**ADC Planning Consultation
Response from the Historic Buildings Adviser**

Application Number	R/73/12/L & R/72/12
Address	2 Manor Cottage, Preston Manor, Rustington
Description	Proposed front porch
Case Officer	Peter Cleveland
Site Visit	16 May 2012

BUILDING REGULATION NOTES

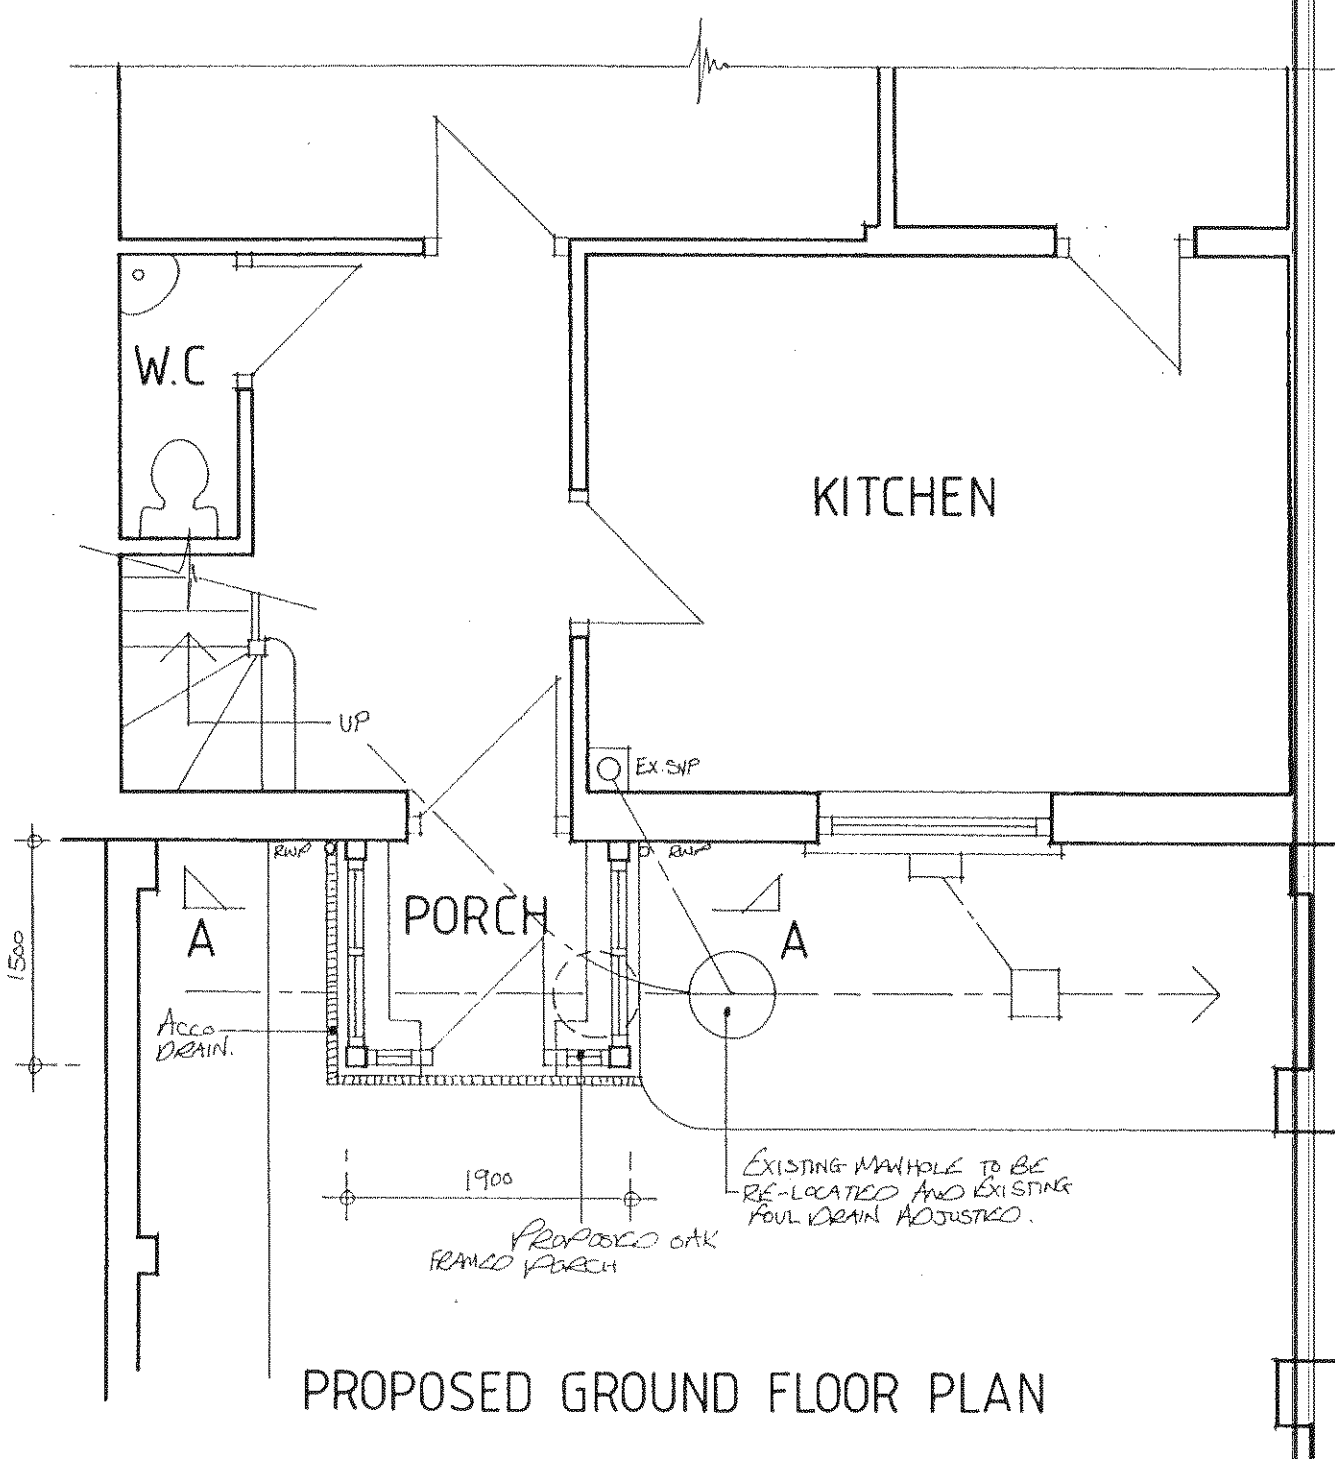
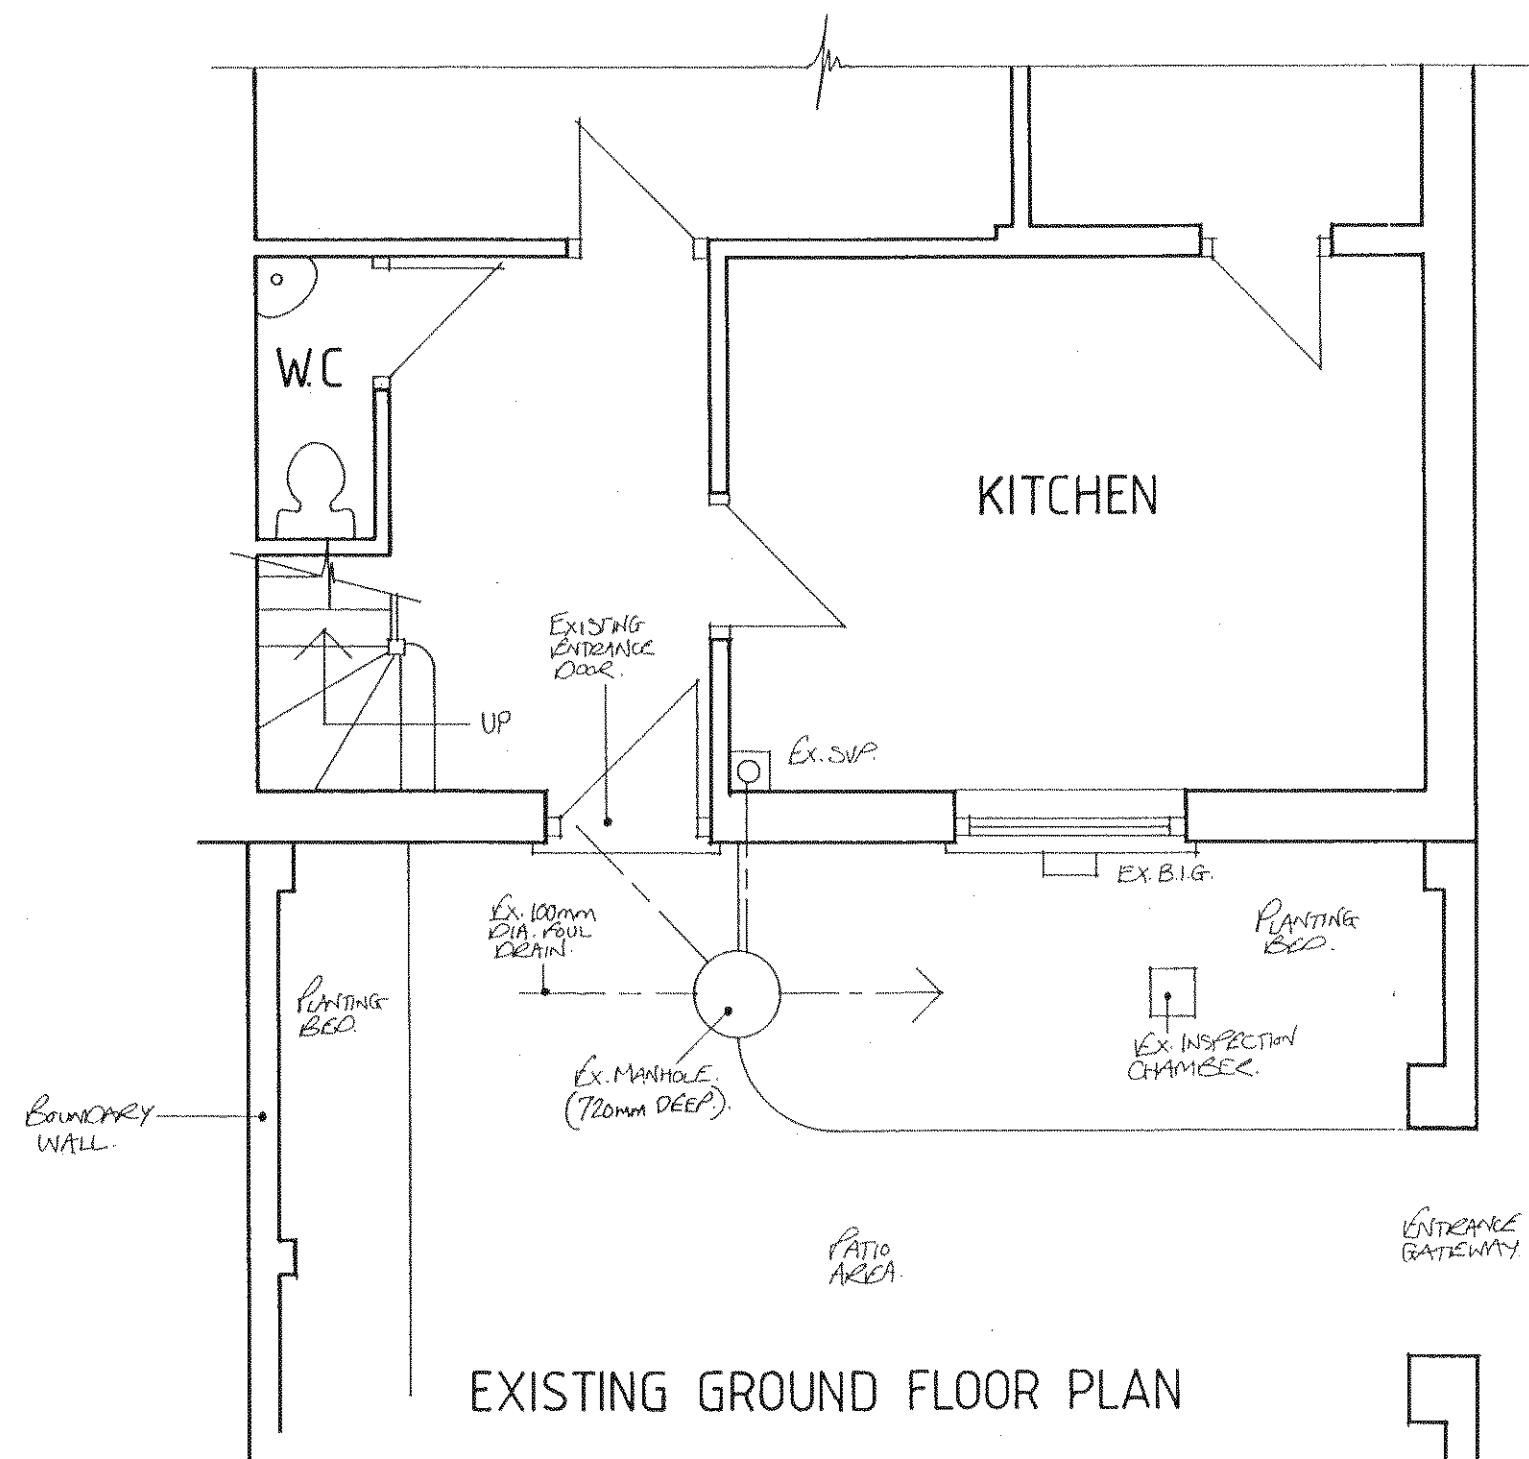
Whilst the cottages that make up the north wing are earlier than the late 19th century Manor House, the rear of these buildings are predominantly ancillary in nature. The variation in roof form suggests some incremental growth here, but not as a cohesive whole and certainly not as a 'facing' elevation. The change from flint with brick string courses to purely coursed flint supports this notion, as does the fact that the flint work (to the north eastern element) matches that of the Manor House to the rear. This seems to suggest that this part of the cottage is contemporary with the Manor house and perhaps reinforces the notion that this building had a service function.

The proposal to add a porch here therefore raises some concerns as it impacts on this character and potentially its special interest. It is certainly not sympathetic with the main building and on this basis cannot be supported.
